Re: 18AWE02 - Air Trunk Response Letter

Travers bushfire & ecology

Environment, Energy and Science (EES Comments)	GEOSCAPES Response	TBE Response
The MAR indicates the MOD 1 proposal would not result in additional biodiversity impacts at the site with respect to SSD-9741 (section 7.6, page 44). According the TAR and VMP for MOD 1 the proposed amendments will have no material change in outcome for vegetation management works surrounding the site. It is noted the power easement is now on the plans to the south western corner of the site which restricts the planting to native grasses within the easement (total area of impact being 200m² (page 2 of VMP and TAR))		Agreed – see response below from Geoscapes
Comparing the LDR for SSD-9741 with the MOD 1 LDR, the MOD 1 proposal will slightly decrease the landscape planting area by 176m², as the MOD 1 has a total area of 14296m² available for landscape planting (section 2.1 LDR, page 2) while the total area for SSD-9741 is 14472m².	Additional APZ planting of 350m² has been proposed underneath the suspended slab. The total landscape area is 14646m² as compared to 14296m² in MOD 1 LDR. The total landscape area has been revised in the amende

LDA-00

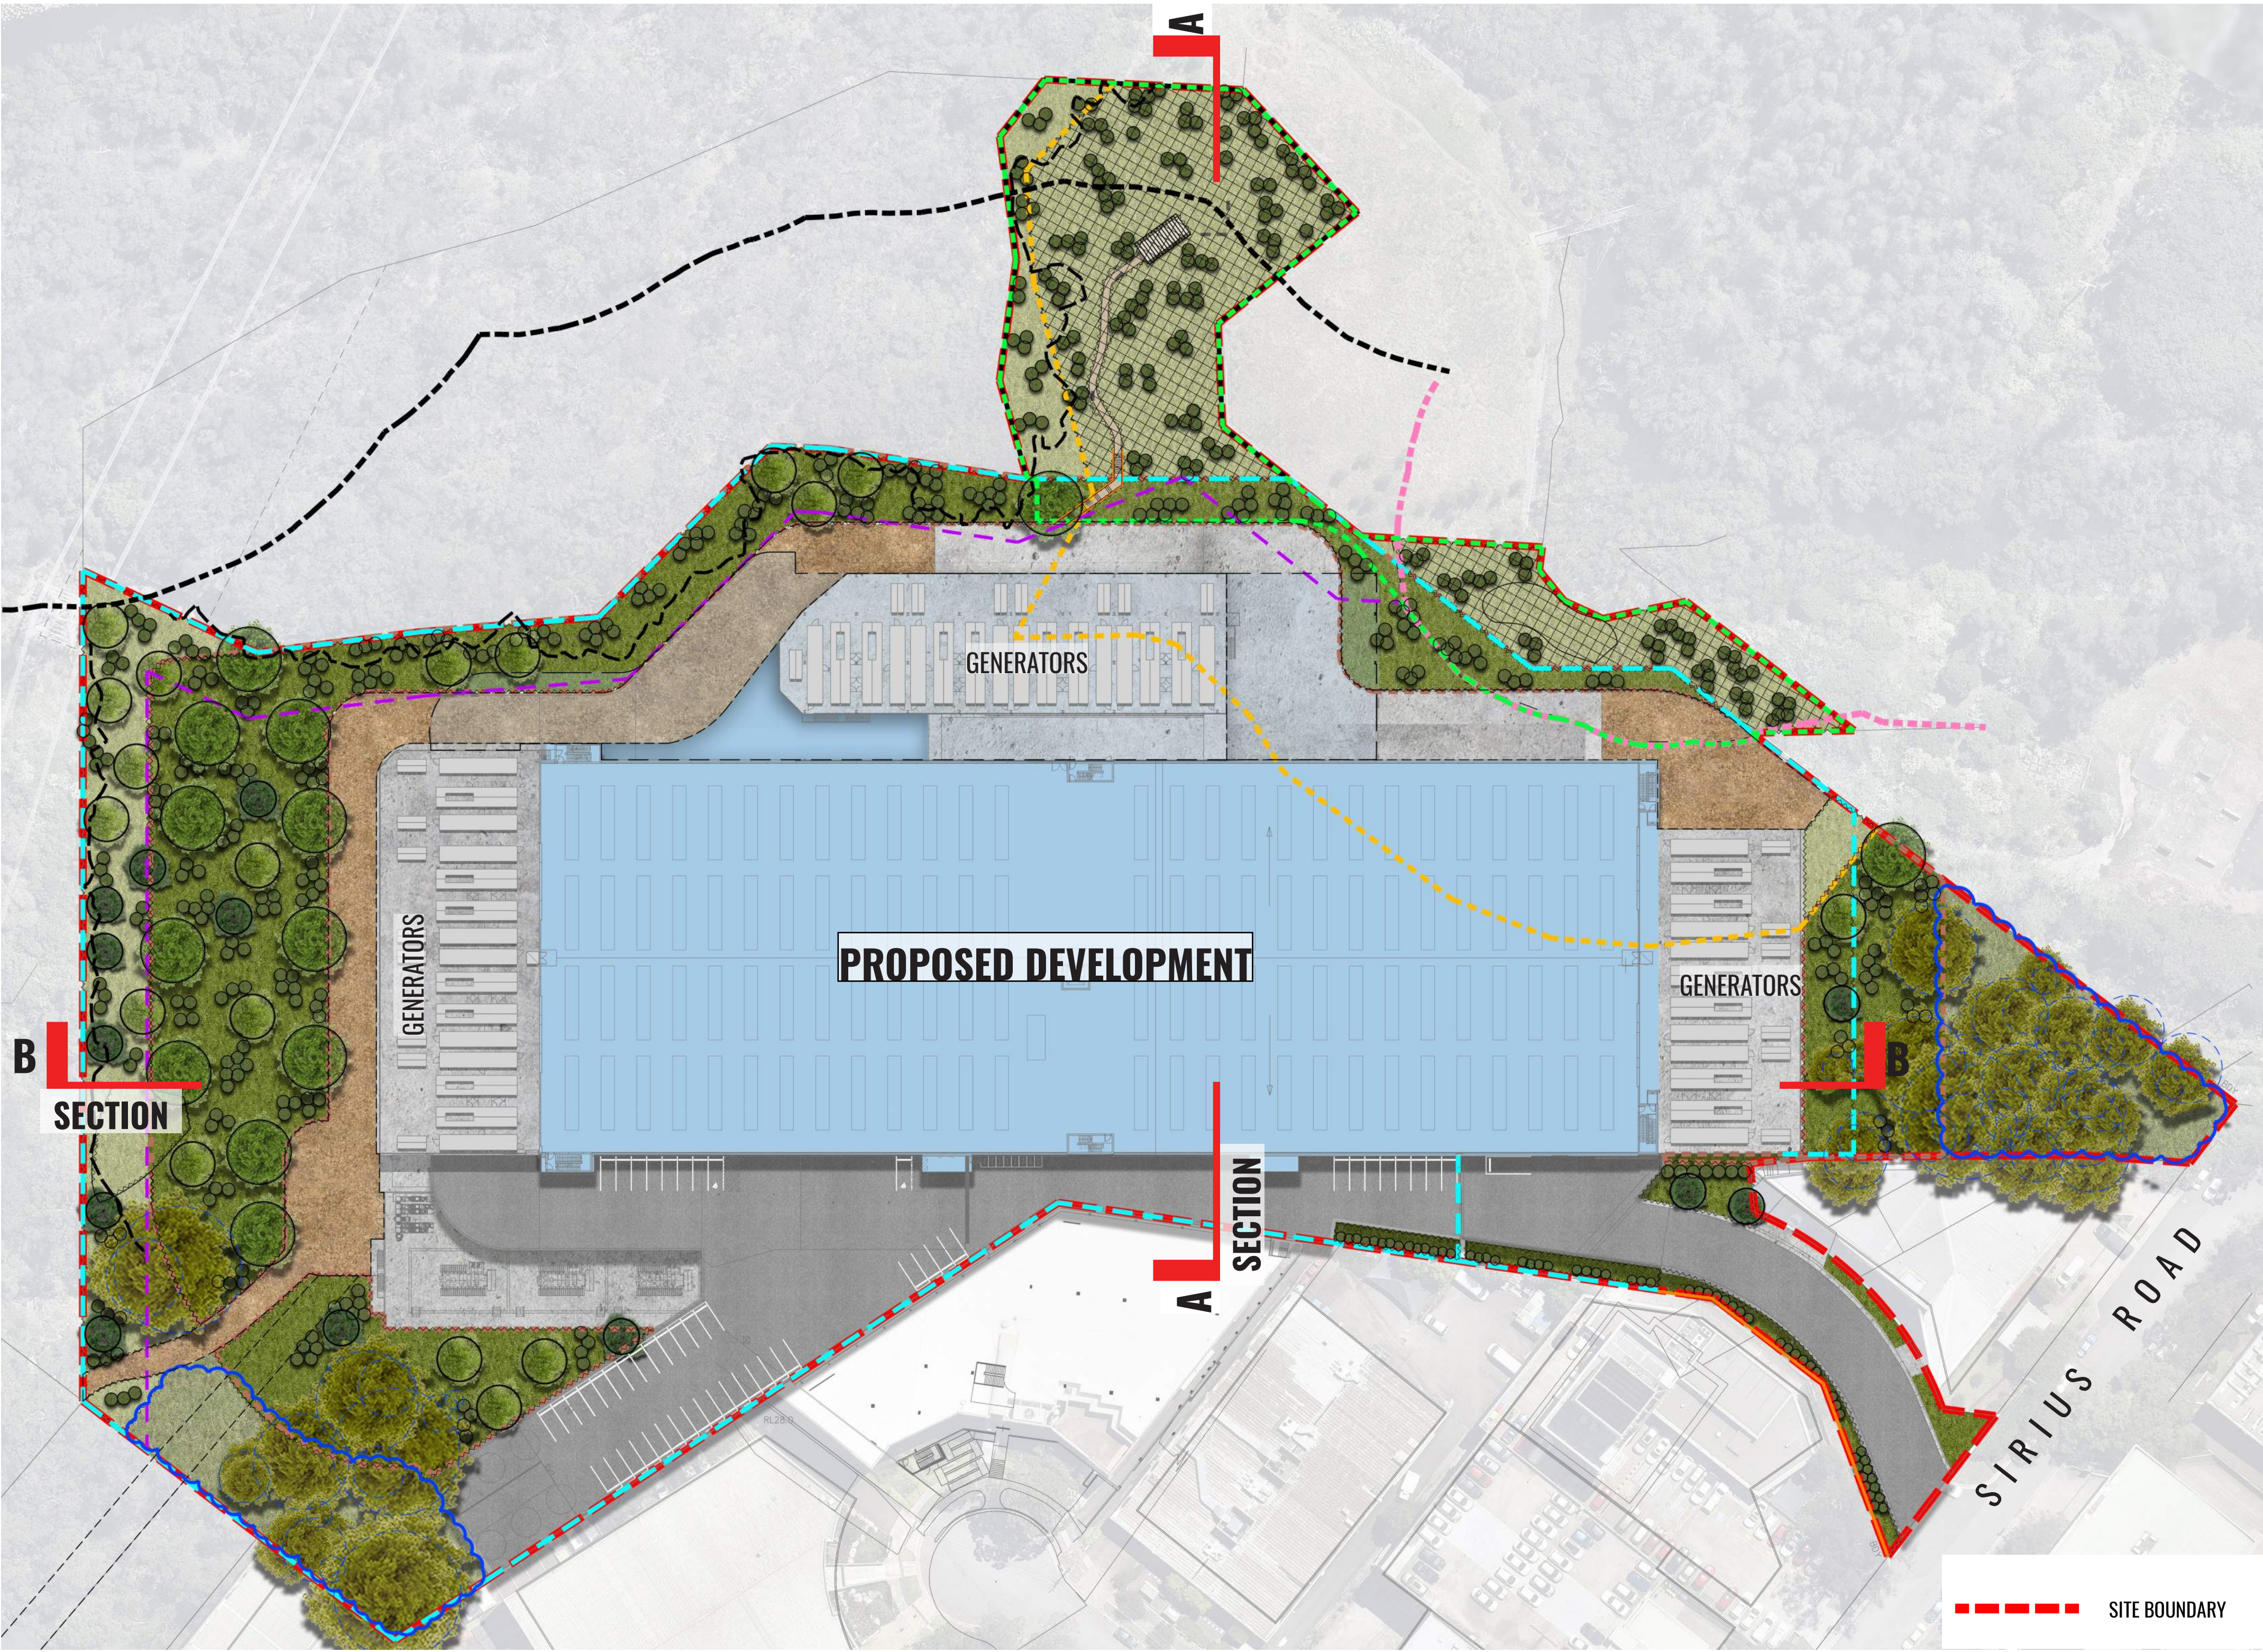
The MOD 1 Landscape Masterplan (LDA-01) near the north east boundary of the site has:	MOD 1 Landscape Masterplan has been amended to suit the modified MOD 1 Architectural layout. The isolated planting to the south east of the vehicular driveway has been included as additional APZ planting and disturbed as indicated in

- Added on APZ area to the east of the vehicular driveway - Removed the isolated planting to the south east of the vehicular driveway	the submitted MOD 1 SSD Landscape Documentation	
The LDA-02 plan for MOD 1 differs to the approved LDA-02 plan in that the marked area is identified as “swamp Oak Floodplain Forest – Contaminated Land as per VMP groundcovers” and Swamp Oak Floodplain Forest – Contaminated Land as per VMP shrubs”. Clarification is required on this	Due to the removal of isolated planting to the southeast of the vehicular driveway as indicated in the approved plan has been amended to the APZ planting as per the updated VMP (Dated: January 2020 REF: 18AWE02UV) prepared by Travers Ecology.	
The approved plans LDA-01 and LDA-02 for SSD-9741 differ in that LDA-01 indicates that the marked patch is “isolated endemic tree and shrub planting outside of 10m buffer zone” and LDA-02 indicates it is “APZ planting groundcovers” As this patch is proposed to be removed by MOD 1, the proponent needs to clarify if this area is meant to be endemic tree and shrub planting or only groundcover planting.	Approved plans for SSD-9741 LDA-01 indicate isolated endemic tree and shrub planting. LDA-02 indicates APZ planting groundcover as listed, individual shrub numbers and individual tree annotation (Screen shot attached) Although this area is proposed to be removed in MOD 1 this planting has been disturbed throughout the site in the other APZ areas.

DWG No:
LDA-05

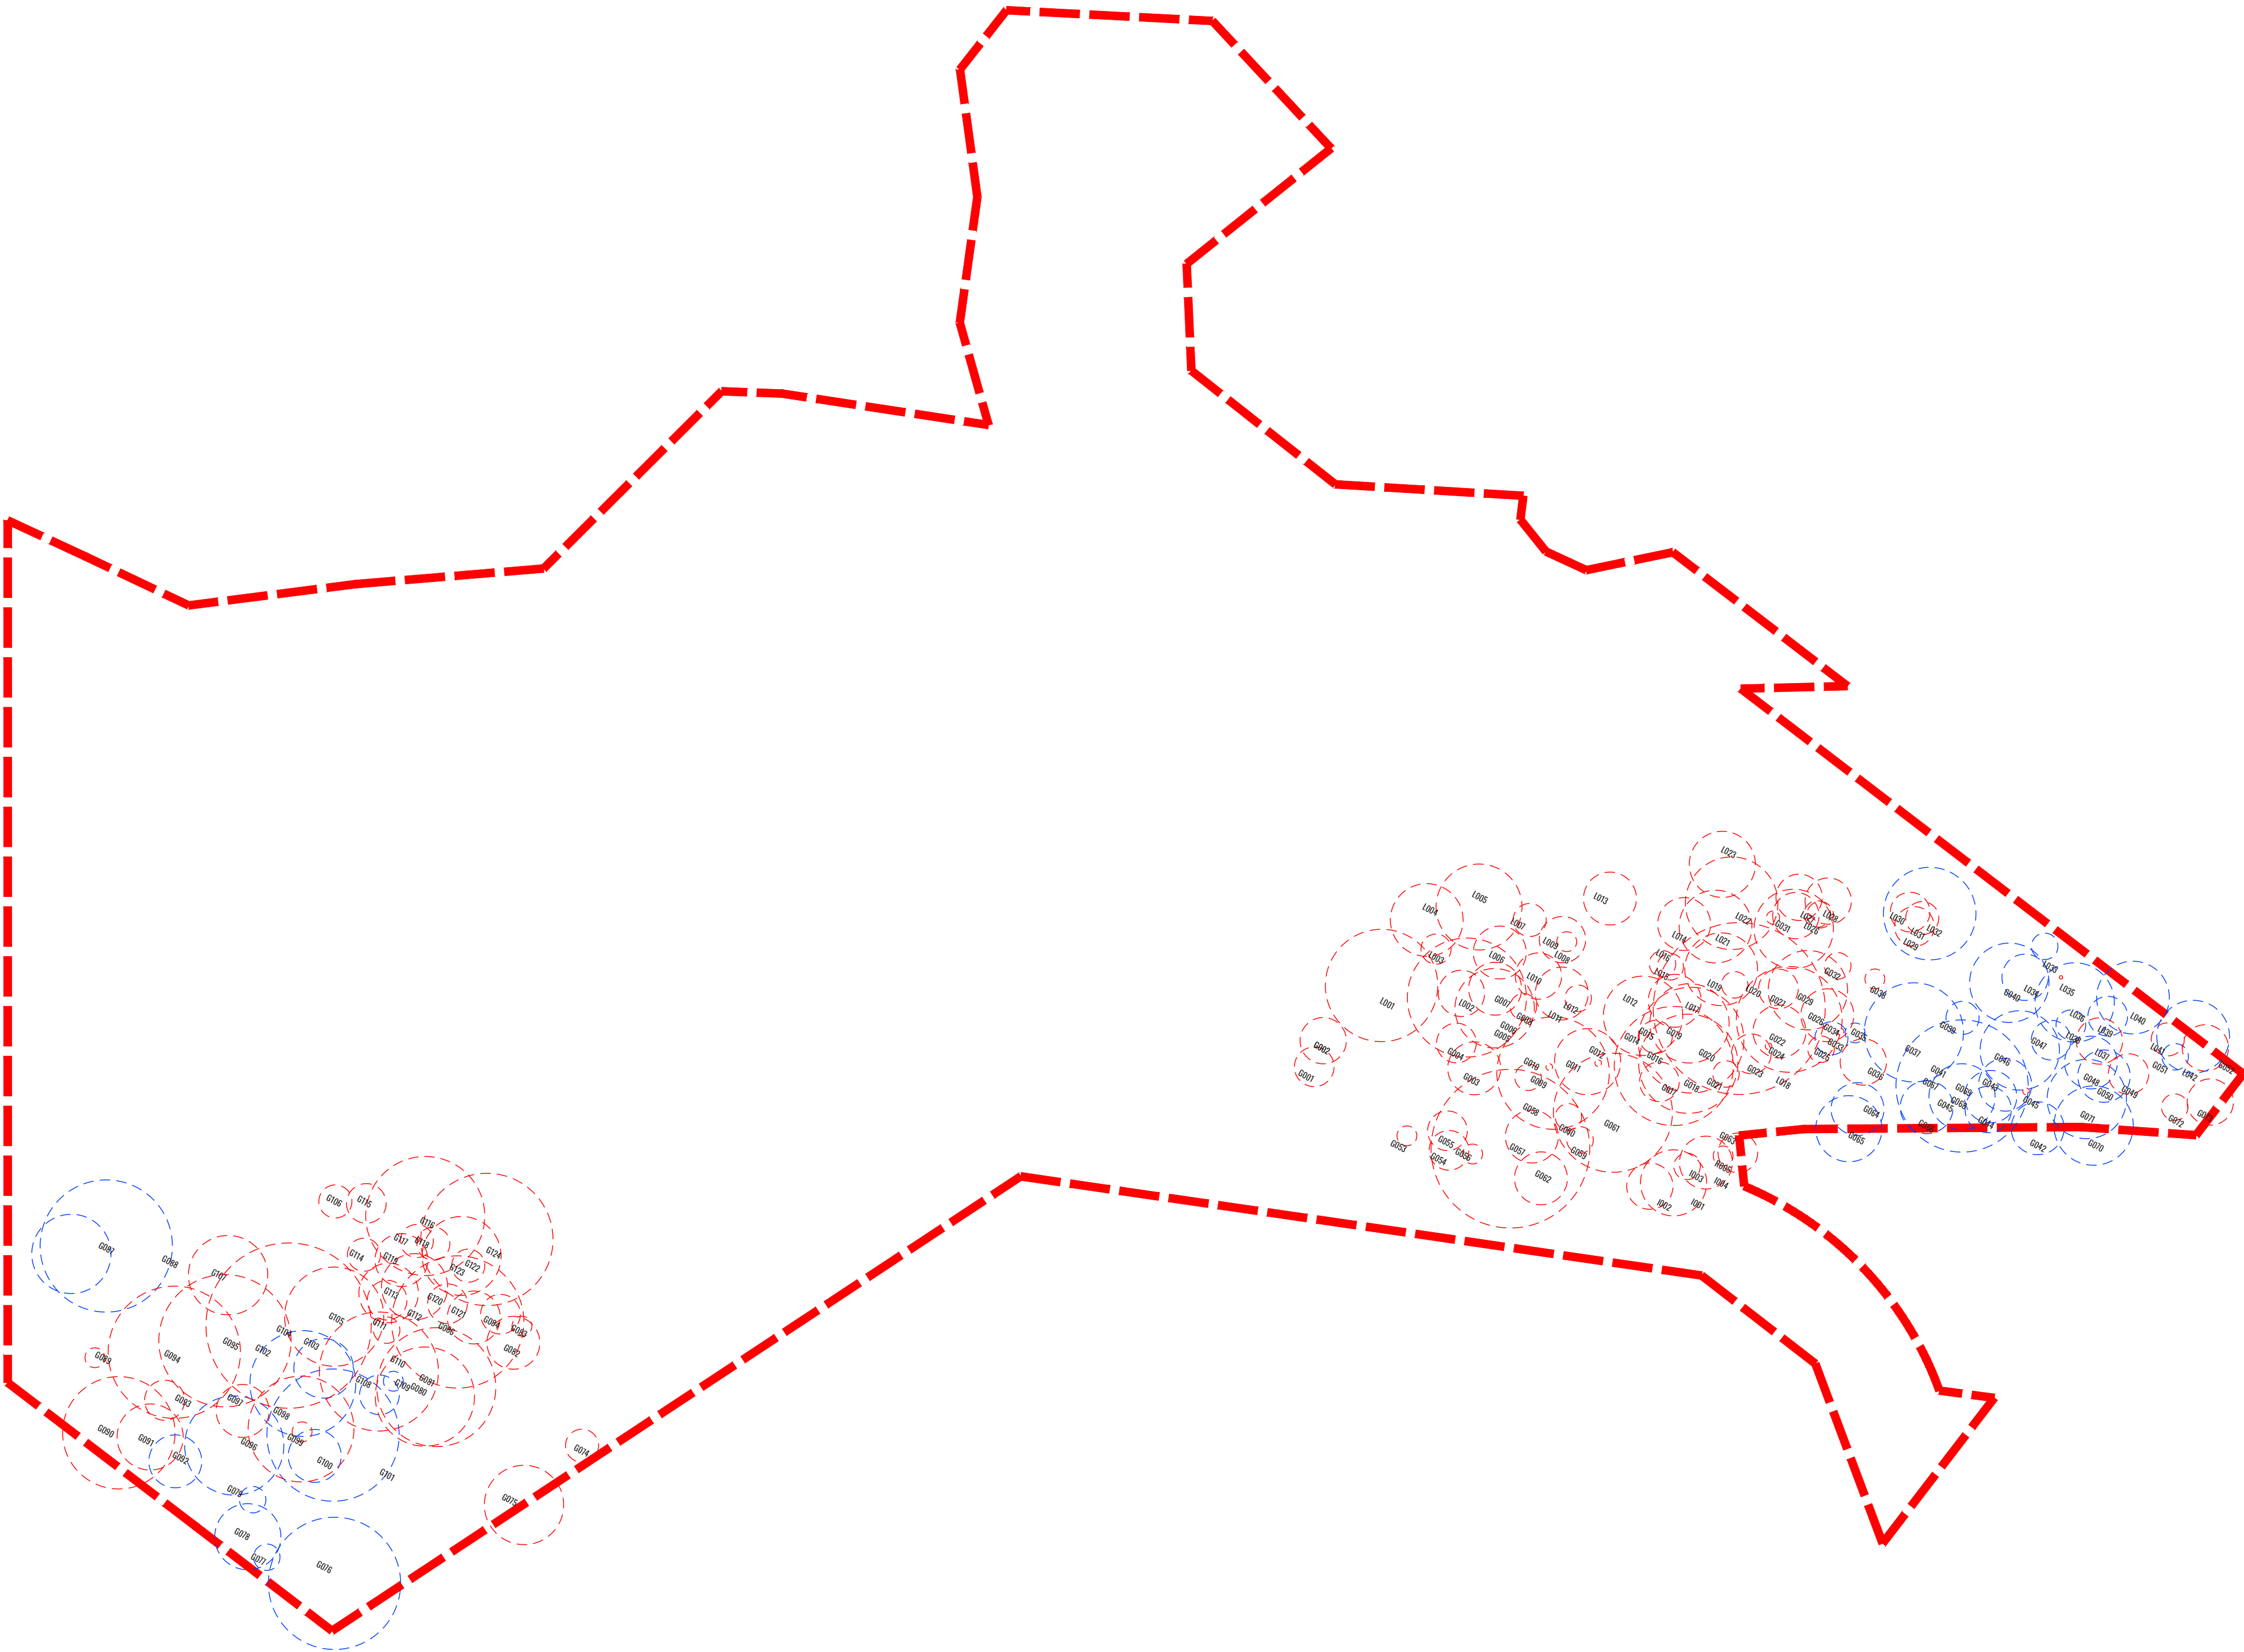
Comparing the TAR (August 2019) for SSD-9741 with the TAR for MOD 1 an additional 5 trees are proposed to be removed – the total number of trees to be removed has increased from 122 to 127 trees (compare section 4.3 in both reports). The proponent should explain why an additional 5 trees are to be removed. EES notes nine invasive/exotic trees are also now to be removed. EES previously recommended in its submission of October 2019 on the amended EIS/RTS that 11 exotic/invasion tree species should be removed. The proponent should clarify why the MOD 1 proposal only proposes to remove nine of the 11 invasive trees		Agreed – Total planting has been increased to 150 Canopy and subcanopy trees in areas to be fully revegetated. The landscape plans did not have the full complement of planted canopy and subdominant species and was therefore modified to be compliant with the VMP density specifications

The MOD 1 TAR indicated the recommended revegetation works proposes to plant an additional 53 trees within the subject site (section 6.4, page 17). Clarification is required as to whether: the ‘additional 53’ trees mentioned in the TAR are in addition to the 53 canopy trees and		Agreed - The landscape plans did not have the full complement of planted canopy and subdominant species and was therefore modified to be compliant with the VMP density specifications

67 sub-canopy trees that the VMP for the MOD 1 proposes to plant as part of Stage 1 within the bushland area which amounts to 120 trees in total (page 20). The proponent should clarify the total number of trees proposed to be planted.		
The proponent should clarify if the MOD 1 proposes to replace the 127 trees to be removed at a ratio of greater than 1:1 in accordance with the Development Consent for SSD-9741 which includes the following mitigation measure 20(e) in Appendix 3 and requires that: (e) Any trees that are to be removed from the site are replaced at a ration greater than 1:1	Total number of tree site wide is now 106 (site wide) - 35 Large Canopy Trees and 35 Sub Canopy Trees within the Bush regeneration and structured Smooth barked apple – Red Bloodwood forest have been proposed - 13 Large Canopy Trees and 23 Sub Canopy Trees indicated within the APZ Total number of trees to be removed it TAR = 122 Number of trees retained in TAR = 44 Total Number of Trees (site wide) = 150
